Meeting Minutes - Peer Review Process: Architecture Design Review Panel

Rozelle Village

Redevelopment of Balmain Leagues Club - Victoria Road, Waterloo Street and Darling Street, Rozelle
V2: 191211

Date:	12 December 2011
Meeting No:	Meeting 4: Design Development Presentation
Location:	Rozelle Village Information Centre, Rozelle
Time:	1.00pm
Attendees:	Panel Members Ken Maher (KM) – Chairman, Hassell Alec Tzannes (AT) – Director, Tzannes Associates Helen Lochhead (HL) - NSW Deputy Government Architect Tony Caro (TC) – Director, Tony Caro Architecture Property Developers Ian Wright (IW) - Rozelle Village Pty Ltd Alex Yasumoto (AY) - Rozelle Village Pty Ltd Architects Frank Stanisic (FS) - Stanisic Associates Jason Nowosad (JN) - Stanisic Associates (scribe)
Apologies:	None
Attachments	Design Development Presentation

OPTION L

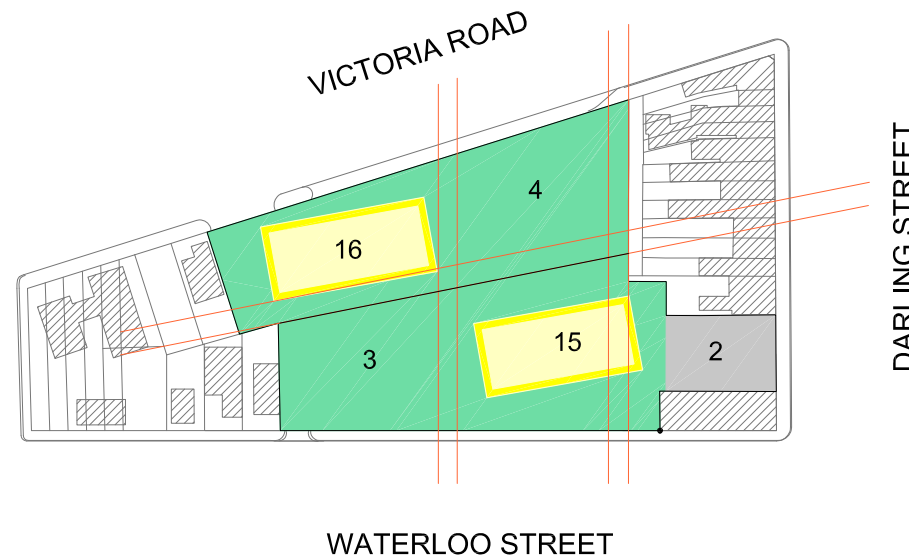
- KM questioned which option impacts the least number of properties by overshadowing. AT commented that option L is slightly better.
 - TC questioned why option L is preferred over option J. KM + AT commented that option L maximise views from the site and minimises overshadowing to surrounding residential properties. AT added that this option supports the principle that the high-rise form is disconnected from the podium and the street.

- TC commented that the visualisations from the street show that option L presents a broad face of the taller high-rise form to Victoria Road and Waterloo Street.

- TC questioned whether the taller high-rise form needed to be reconsidered and made more compact with a central core. FS commented that a primary concern has always been to ensure that the mass on the skyline is minimised. FS added that by breaking the taller high-rise form in two reduces the mass on the skyline. FS added further that this strategy also introduces fresh air into the building and reduces the reliance on air conditioning.

- All panelists agreed that option L is considered the best of the options for the site and it is worth exploring variations to this option to address the slight awkwardness of the smaller high-rise form.

- AT commented that there should be a residential lobby along Victoria Road to provide direct access to the smaller high-rise form.
- HL commented that the single high-rise form and low-rise platform had clarity, which is lost with a high-rise form and transitional building.

- KM commented that the scale and form of the low rise platform and smaller high-rise form should have more in common with the local context. KM added that the smaller high-rise form has an awkward presence.

- KM commented that it may be worth exploring whether the footprint of the smaller high-rise form is increased whether the height of this form could be reduced in a "boot-type arrangement". KM added that this would

- AT commented that the smaller high-rise building should be strengthened by increasing its height. AT added that in order to maintain the same floor space, the portion of the taller high-rise form adjacent to Waterloo Street is reduced in height which would reduce the overshadowing to properties south of Darling Street. AT added further that this option might present an interesting sculptural inter-relationship between the ensemble of high-rise forms where the 3 forms are read together rather than 2 dominant forms and one less dominant form. AT commented that more bulk and height to adjacent to Victoria Road is offset by reduced amenity impacts to surrounding properties.

- FS commented that the view and SEPP 65 solar access requirement do not exactly coincide in order for 3 hours of solar access to be achieved to units facing the city in option L. FS added that in order to achieve 3 hours of sunlight, the high-rise form adjacent to Victoria Road would need to rotate more to the north west. HL added that the view from the site to the city must be balanced against amenity.

- TC commented that option L will present a broad face when viewed from the harbor bridge. KM commented that by reducing the height of the smaller high-rise form, the bulkiness of the building when viewed from the harbour
